RE: **Winrock Road Town Center**
2100 Louisiana Blvd NE
Drainage Master Plan- Drainage Implementation Plan
Engineer's Stamp Date: 4/29/19
Hydrology File: J19D058

Based on submittal received on 4/29/19, the Drainage Implementation Plan cannot be approved for Site Plan for Building Permit until the following are corrected:

STORM DRAIN AP-B 100

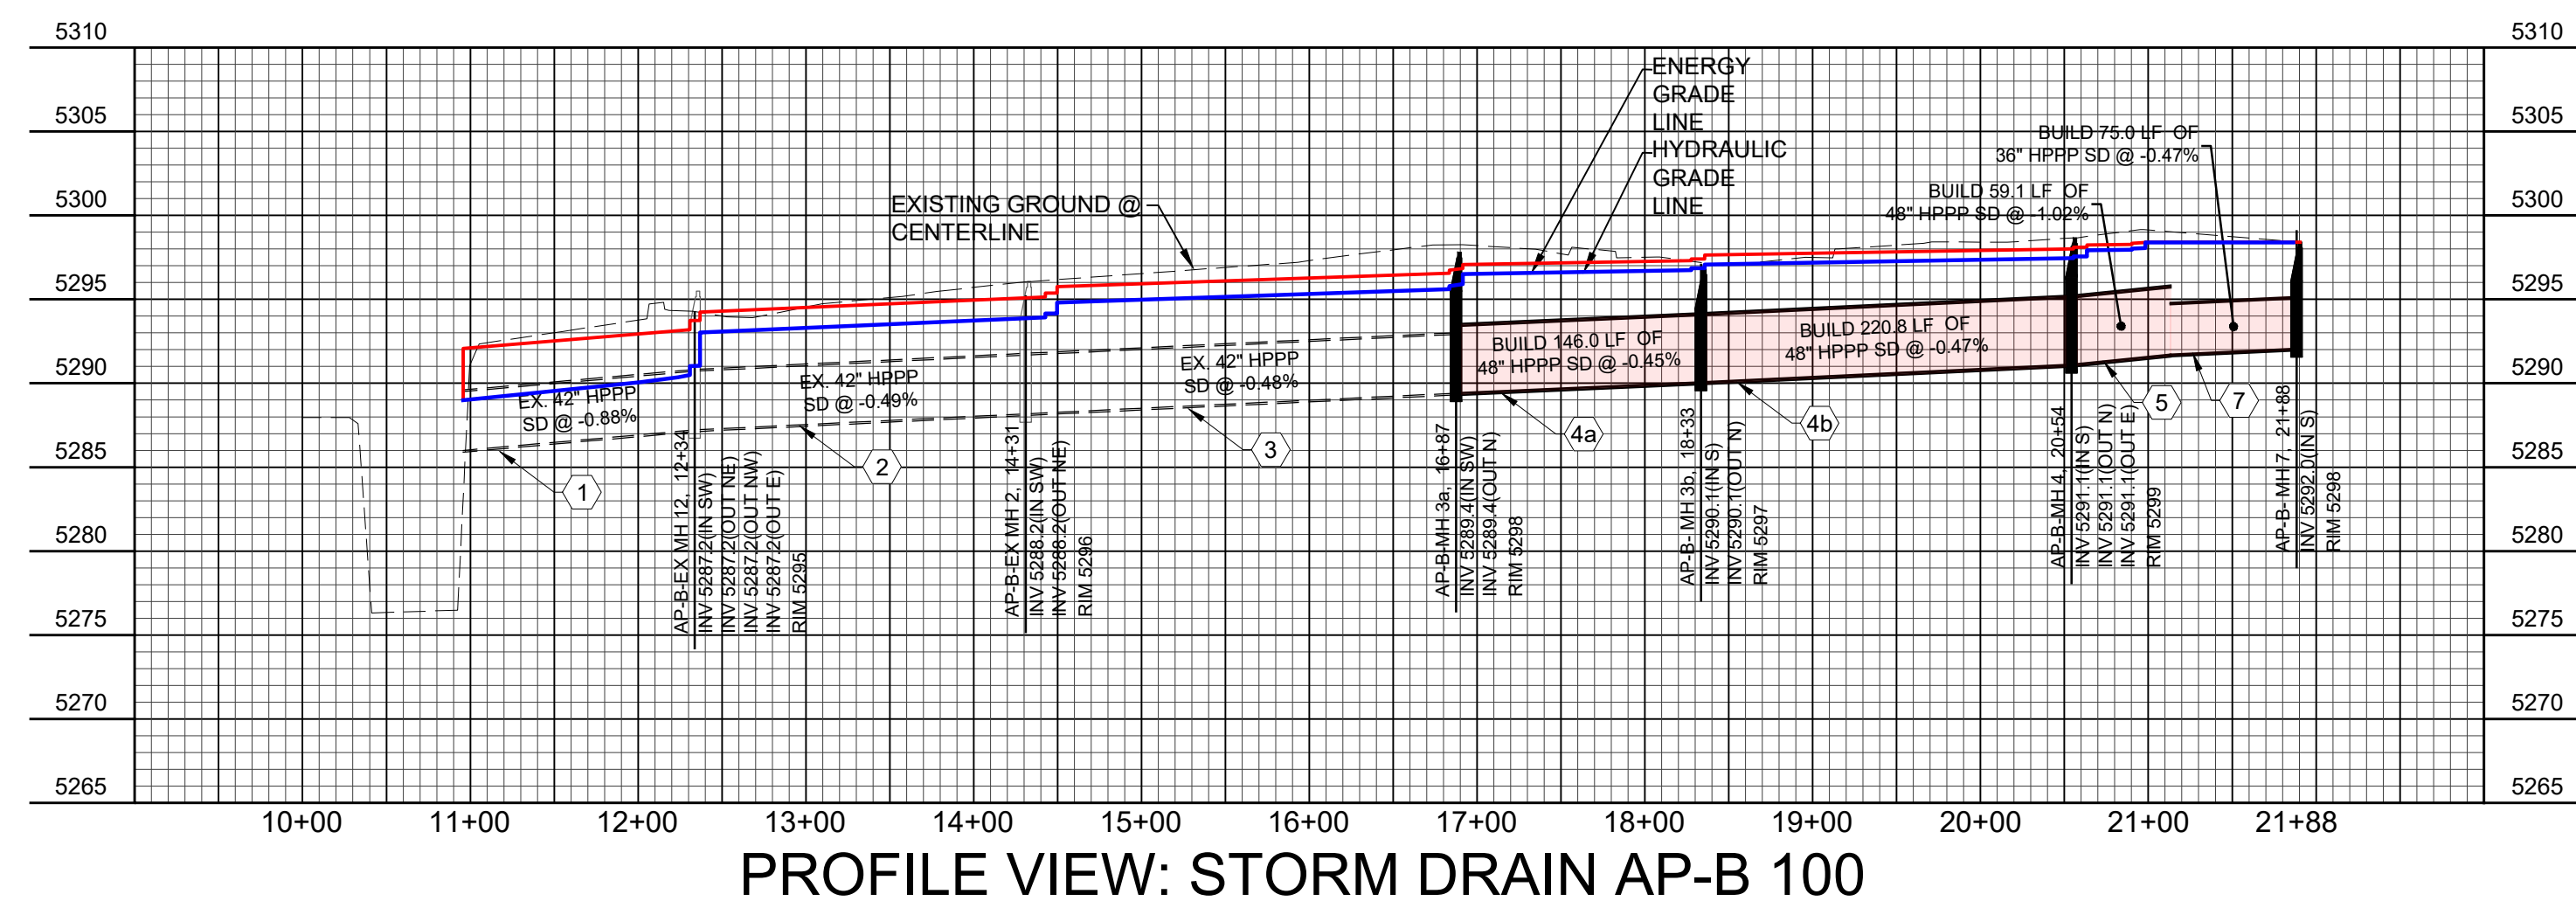
3. Exhibits 2-7 minor remarks:
 - a. Please label the Manholes in plain view and label the pipes in profile view.
 - b. On exhibit 2, pipe 2 appears to be mislabeled in plain view.

WINROCK TOWN CENTER			
PHASE B INFRASTRUCTURE IMPROVEMENTS			
TITLE: STORM DRAIN AP-B 400 & 500			
Design	Review	Committee	City Engineer
Last Update		Ms./Day/Yr.	
		Ms./Day/Yr.	
City Project No.		Zone Map No.	Sheet Of
4553.90		J-19-Z	EXHIBIT 4

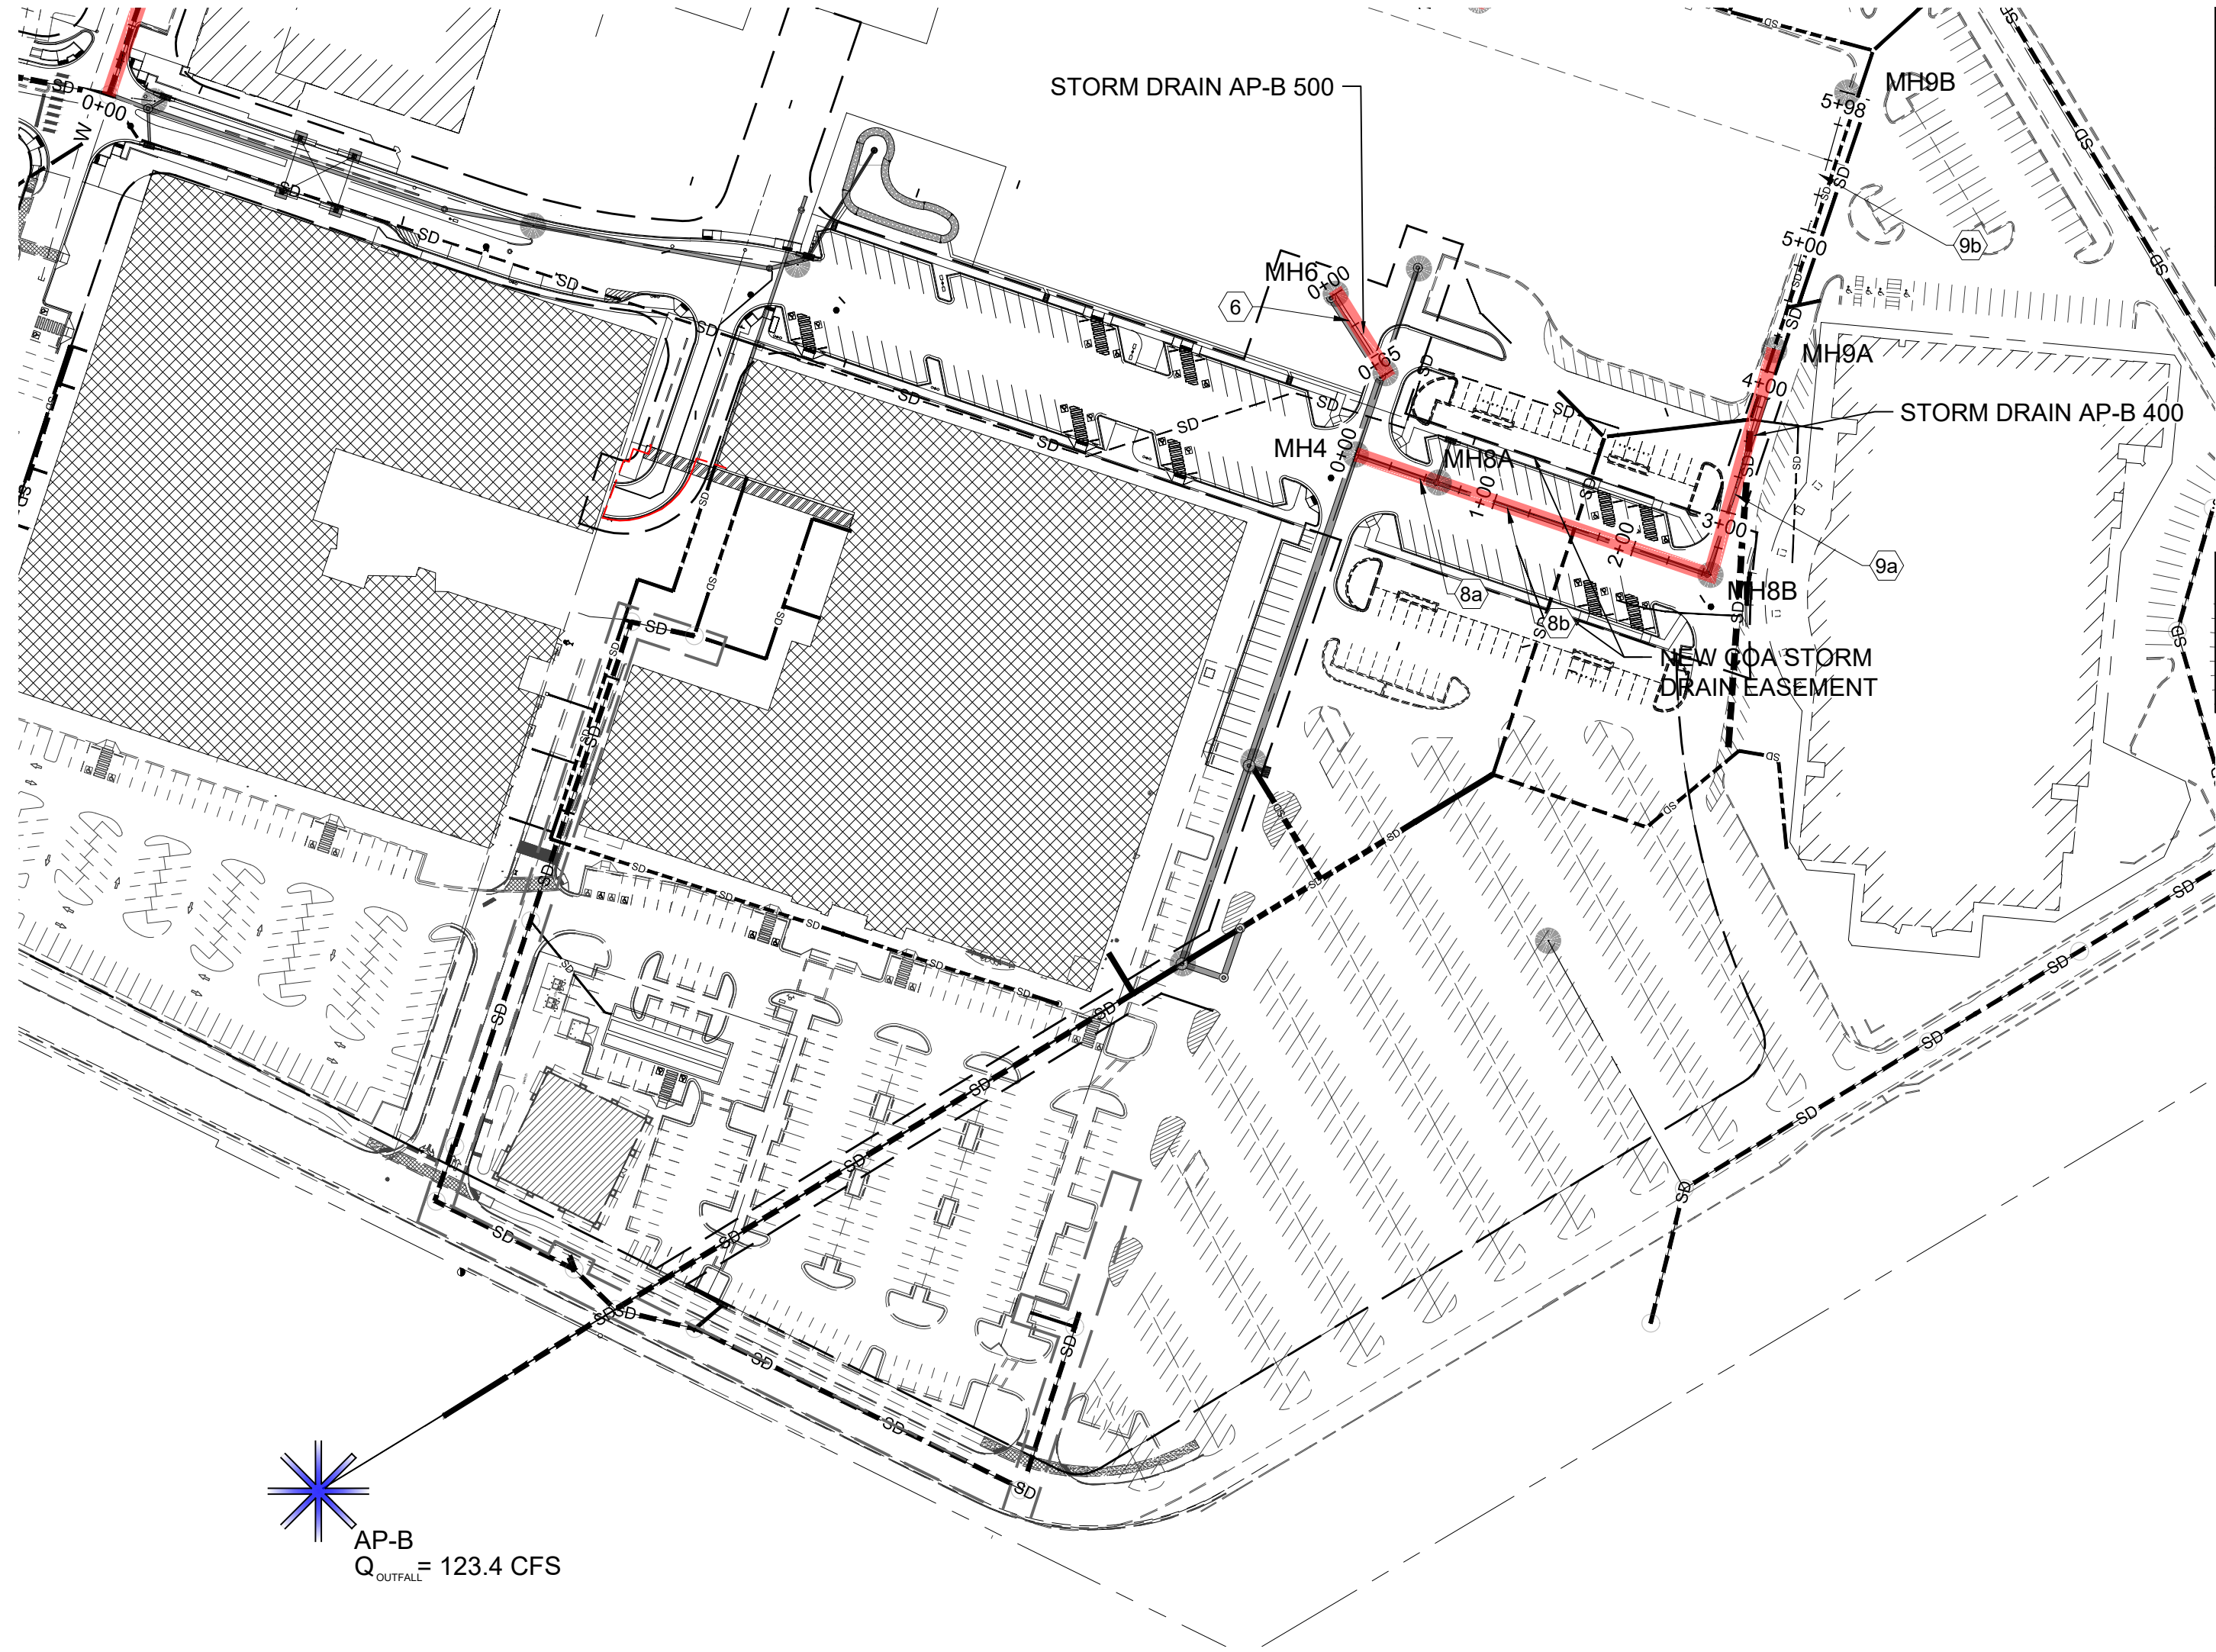
- c. Exhibit 4, the profile for AP-B 400 is cropped.
 - d. Storm drain profiles/model for AP-A are missing
4. In the output tables, relabel the "Flow" column as "Allowable Flow" or similar. Or remove the "Capacity" column. It needs to be clear that the allowable flow to each pipe is established by the hydraulic model (not Manning's).
